## **1/0052/2023/FUL**

Proposal: Demolition of existing building and erection of 1no. dwelling with associated works in lieu of Class Q permission 1/0649/2021/AGMB

On Behalf Of: Environmental Protection Officer

PROPOSED SITE PLAN 1:100 @ A1

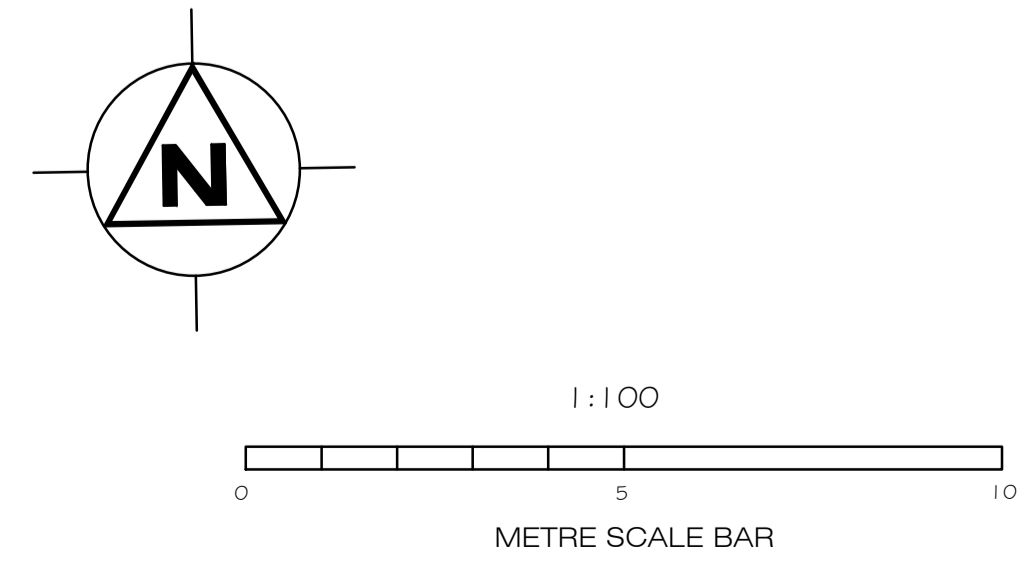
The proposed dwelling is to be served by a new septic tank discharging to a drainage field. Percolation testing has not been undertaken making it difficult to assess whether the ground has sufficient permeability to accommodate the drainage field. Percolation testing will need to be carried out and the results submitted, as well as the calculated drainage field area and location, for review to ensure the proposed dwelling is served by an adequate foul drainage provision.
